**CYNGOR SIR
YNYS MÔN
ISLE OF ANGLESEY
COUNTY COUNCIL**

Dyddiad / Date: 02/10/2018

Review of Horizon's DCO Submission (A5025 off-Line)

Figure 1-2 A5025 Off-line Highway Improvements Section 1

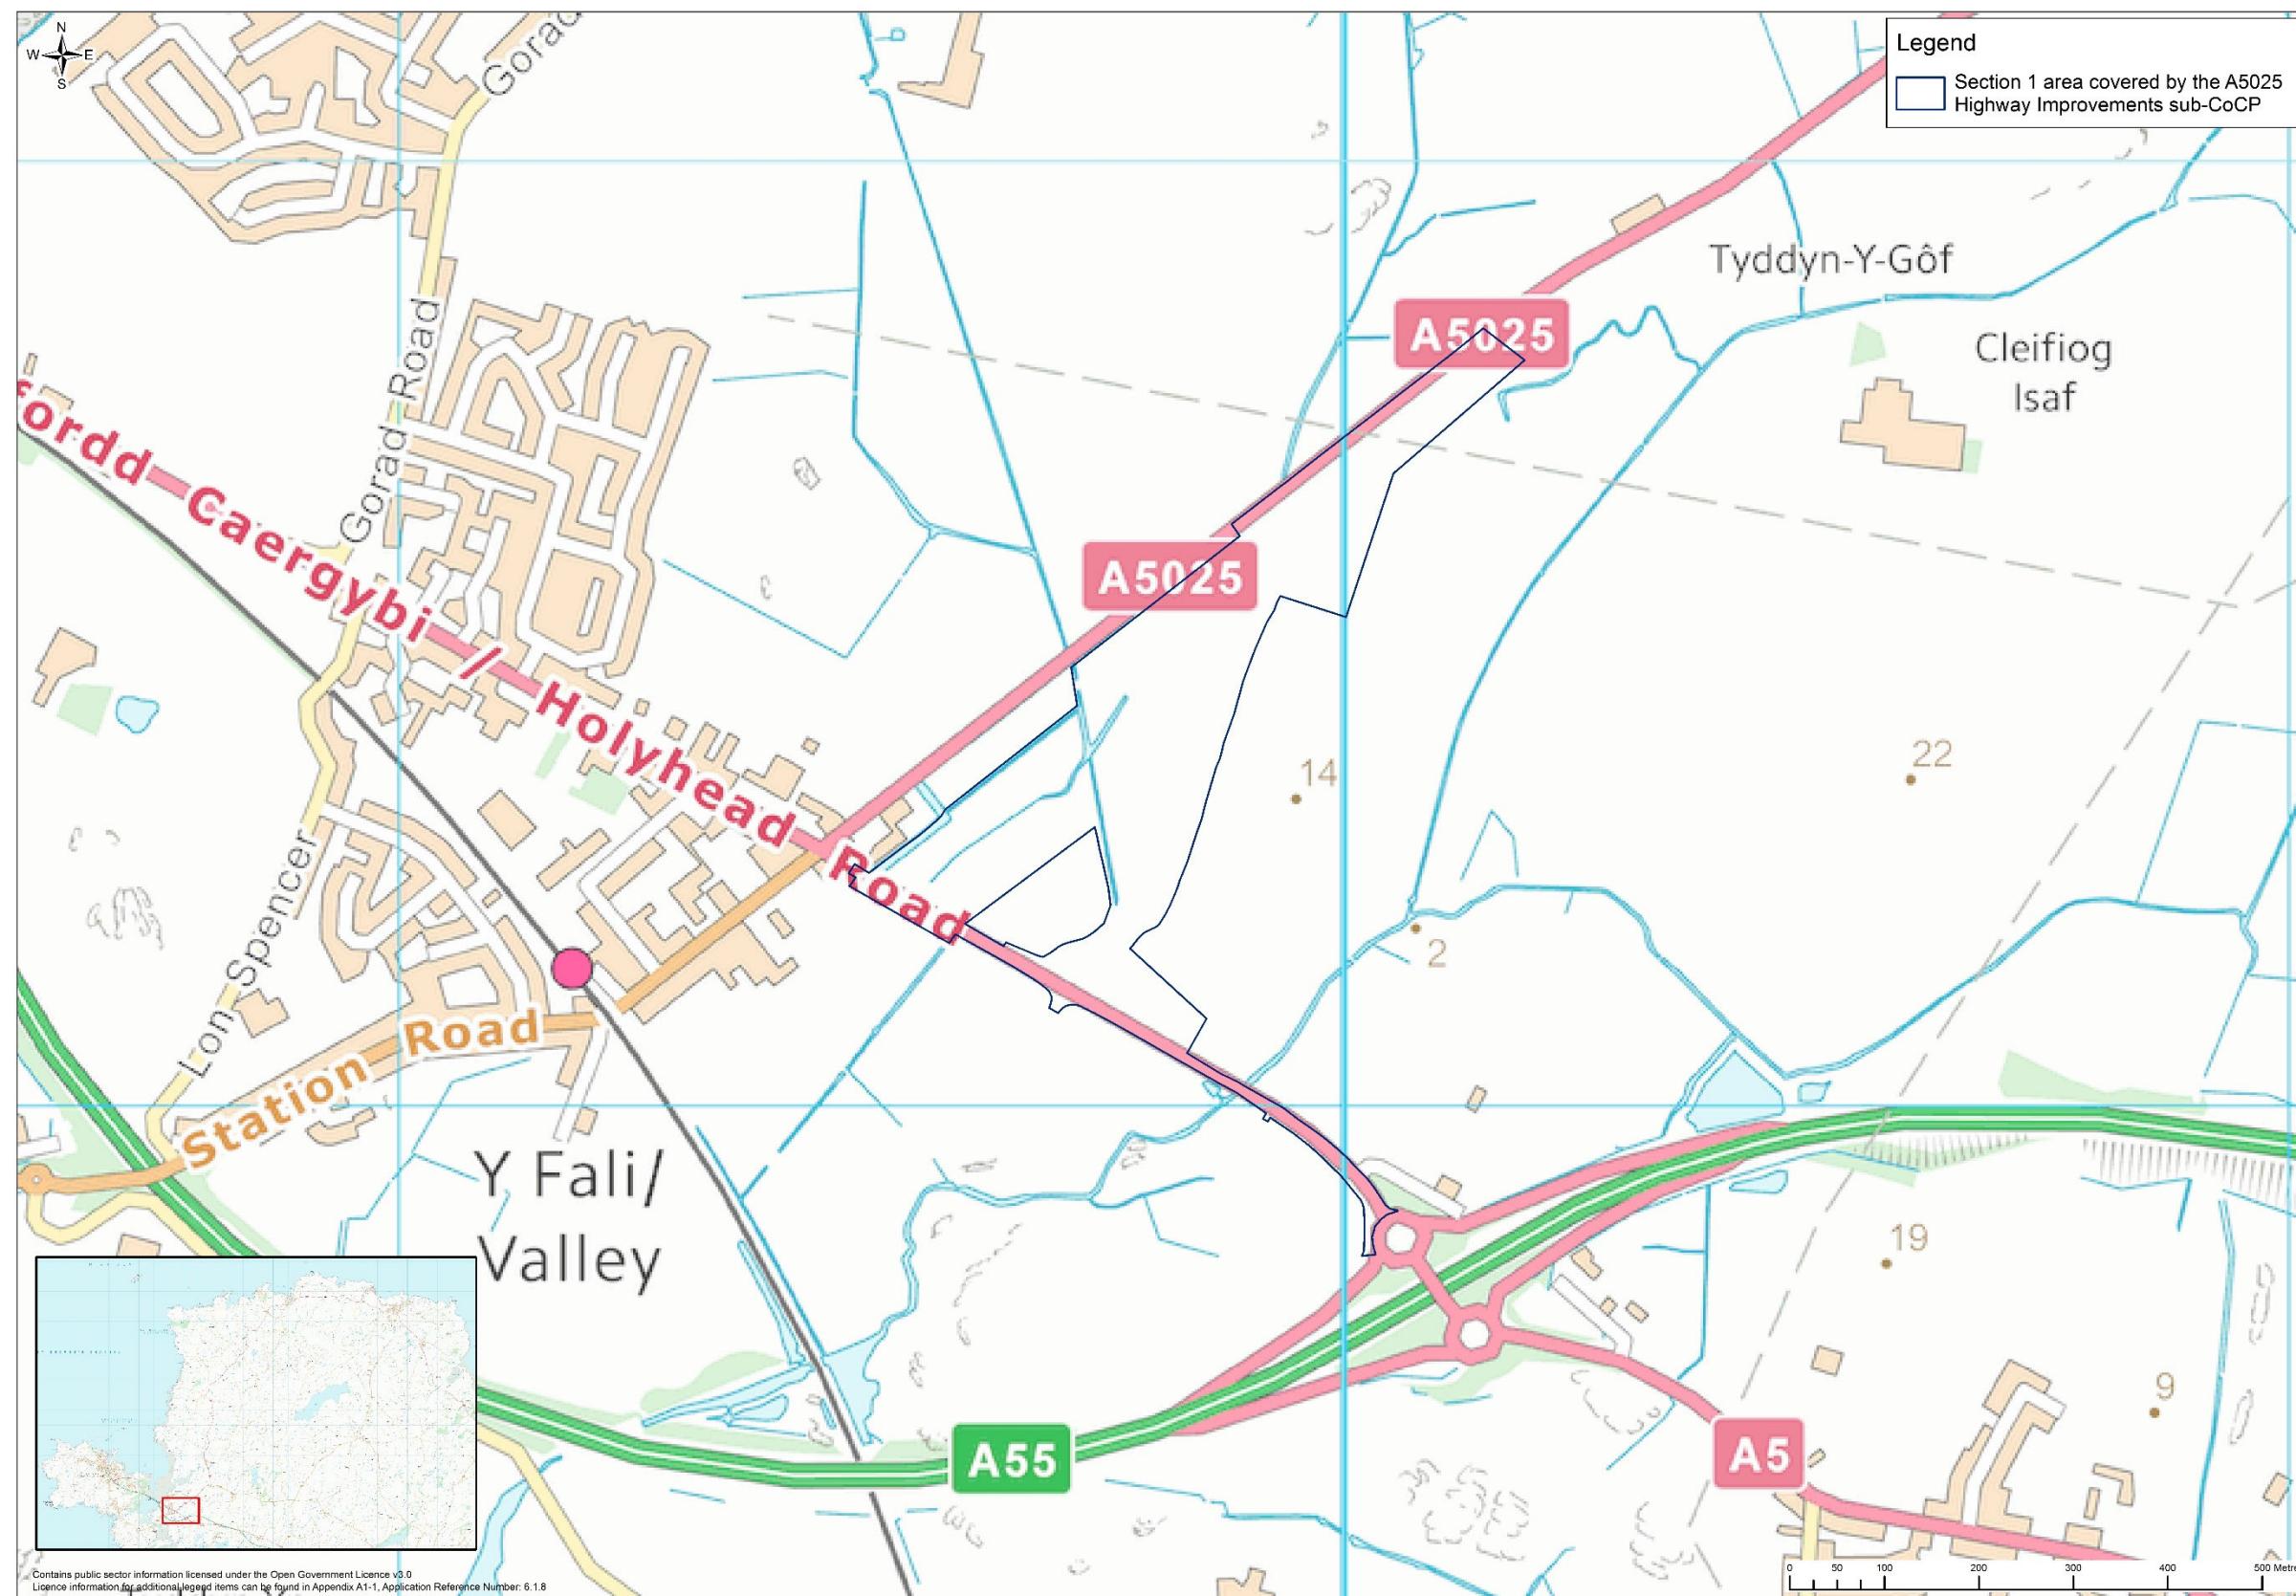
Horizon's conclusion that few archaeological remains of limited value are anticipated appears to be appropriate in the opinion of IACC.

The conclusion that indirect effects are not anticipated appears appropriate.

Figure 1-3 A5025 Off-line Highway Improvements Section 3

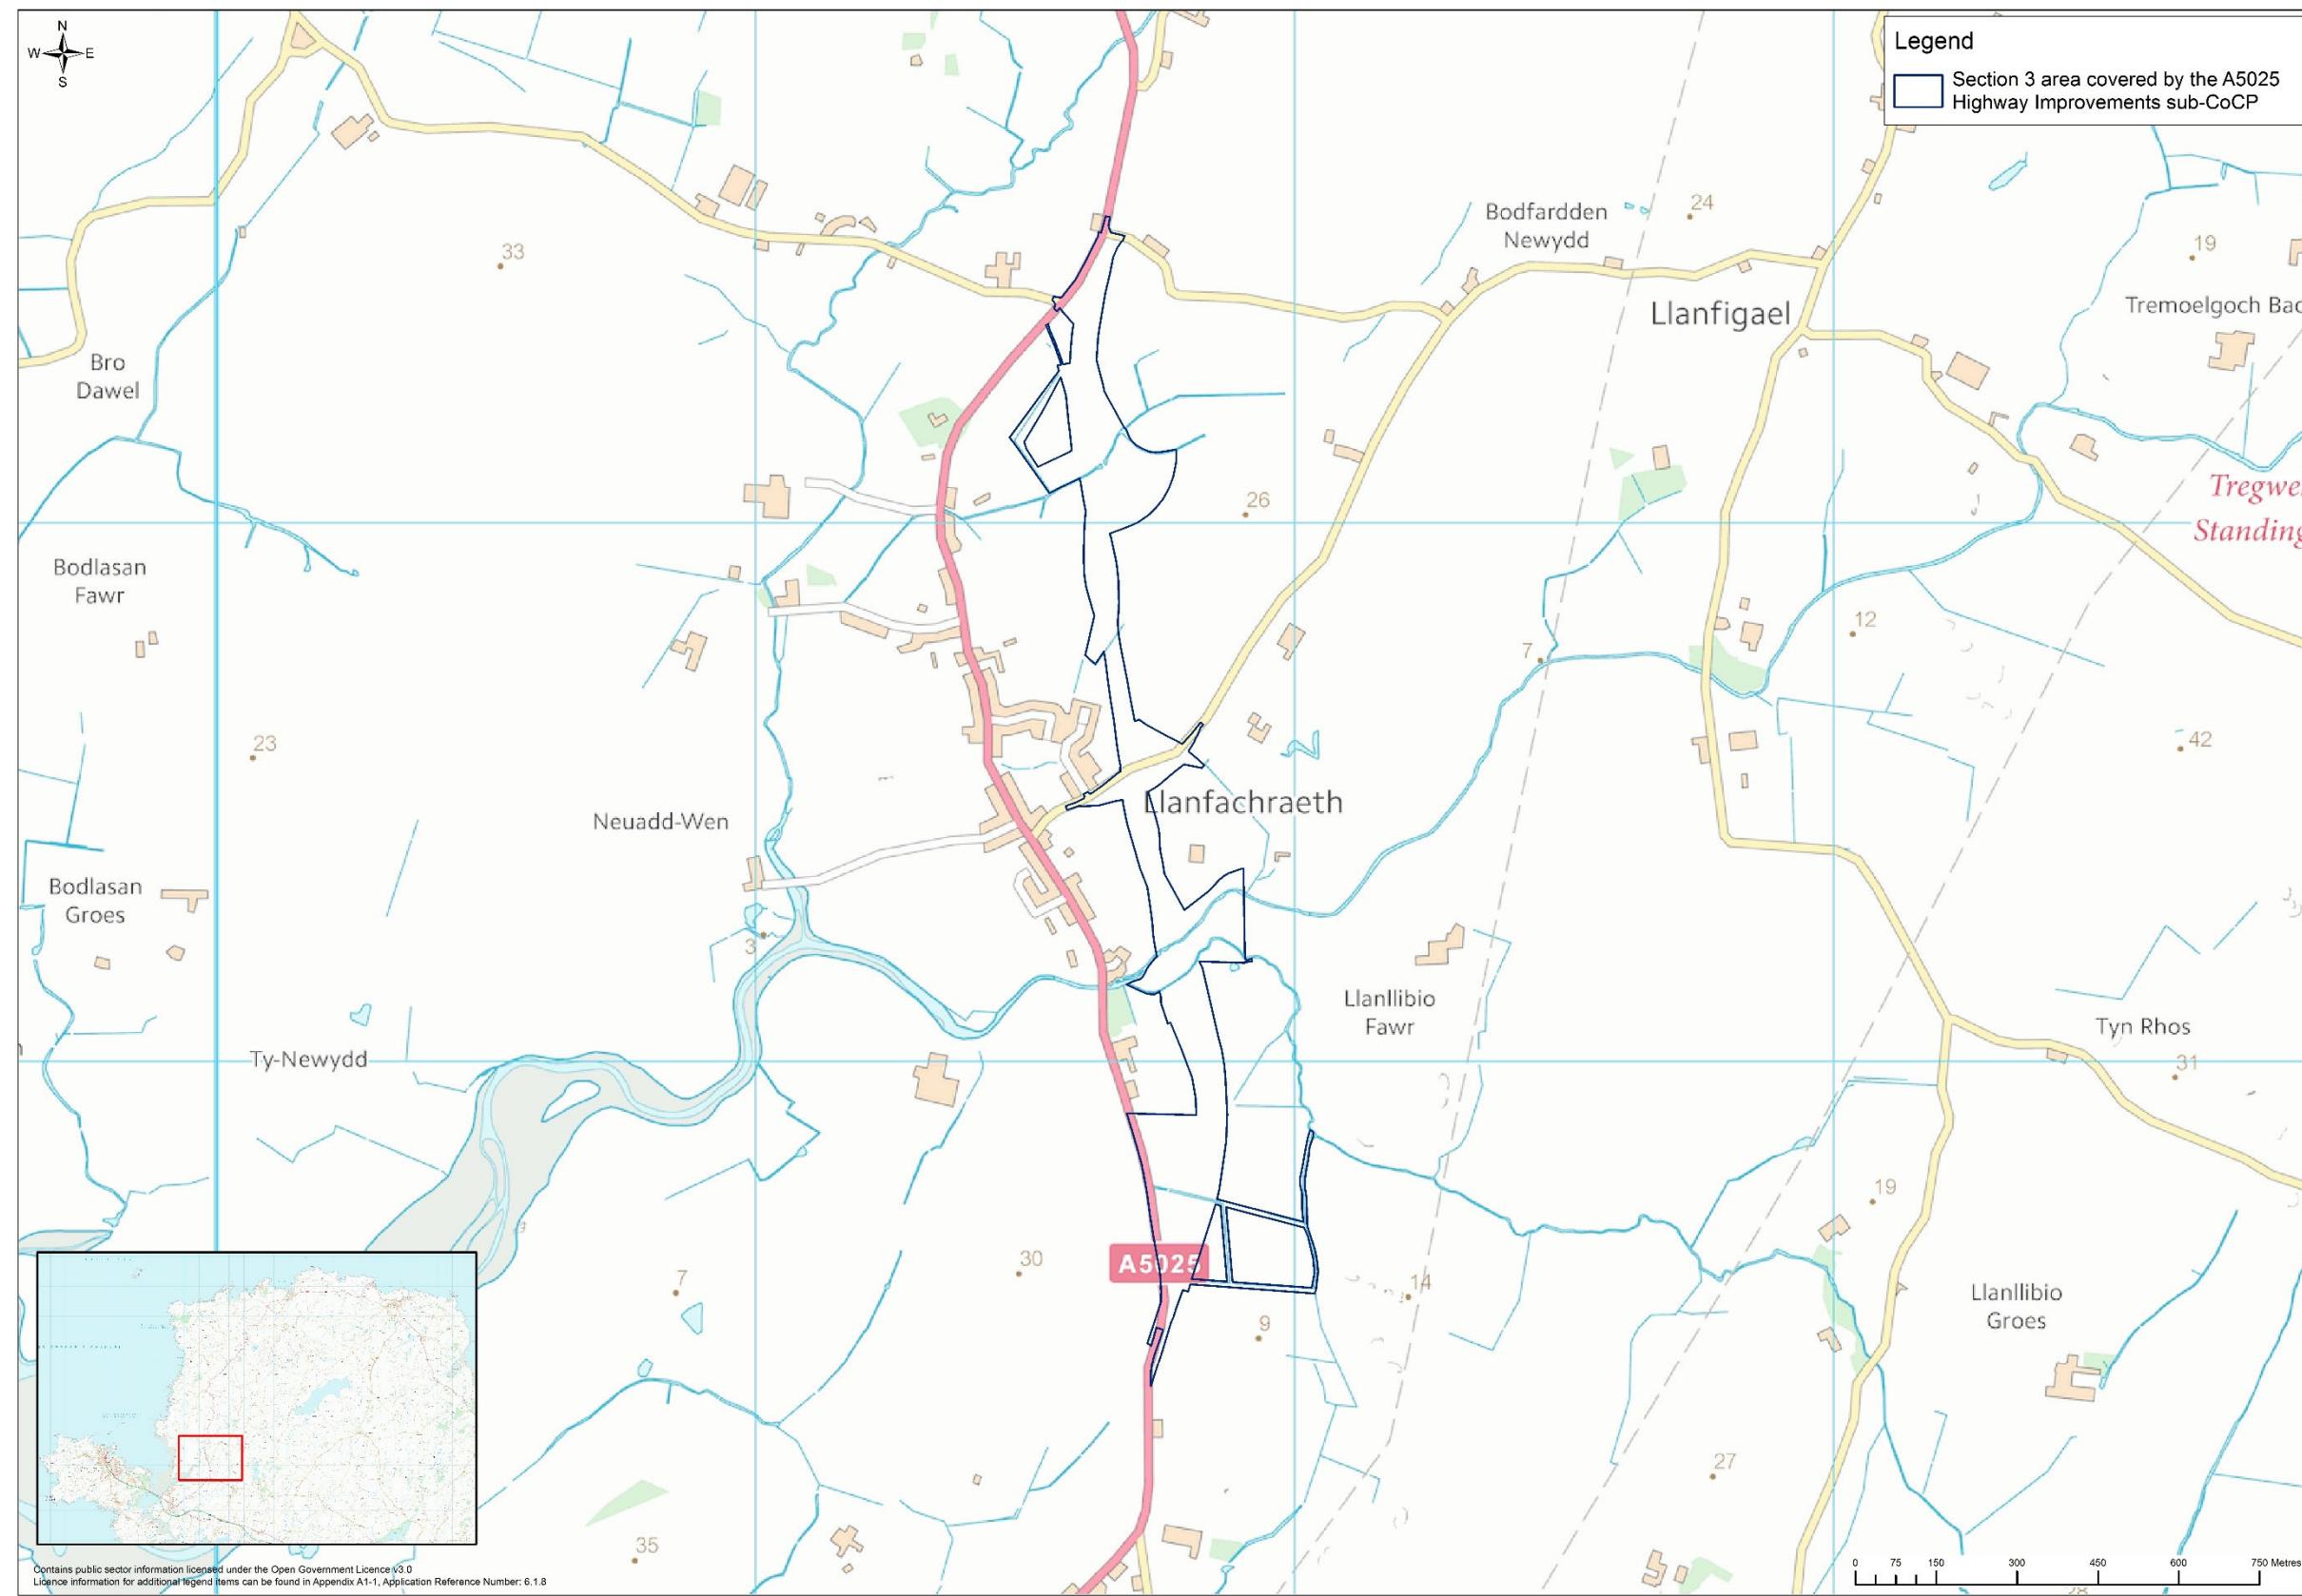
The conclusion that archaeological remains of regional value at most would be affected appears to be appropriate. The IACC does not however necessarily agree that the limited artefactual assemblages identified in evaluation work is such that the archaeological value should be low. Limited assemblage is a characteristic of the archaeological resource for many periods of human activity in this area. Notwithstanding, whilst some assets might in the opinion of IACC be valued as medium, as opposed to low, this would not materially affect the overall conclusions of the assessment.

The assessment that no significant adverse effects would arise on the setting of heritage assets appears appropriate. It is not clear to what extent the diversion of through traffic from the village and on to the proposed bypass would present an enhancement in the settings of the listed buildings along the road frontage within the village, particularly in terms of noise as this aspect of the works is not considered in the ES.

IACC notes that there would be an increase in flood risk at one residential receptor in Section 3 (Afon Alaw viaduct). The assessment concludes that detailed design will be able to prevent this minor increase in flood risk but IACC would wish to understand the fall-back position should such design prove physically/financially infeasible.
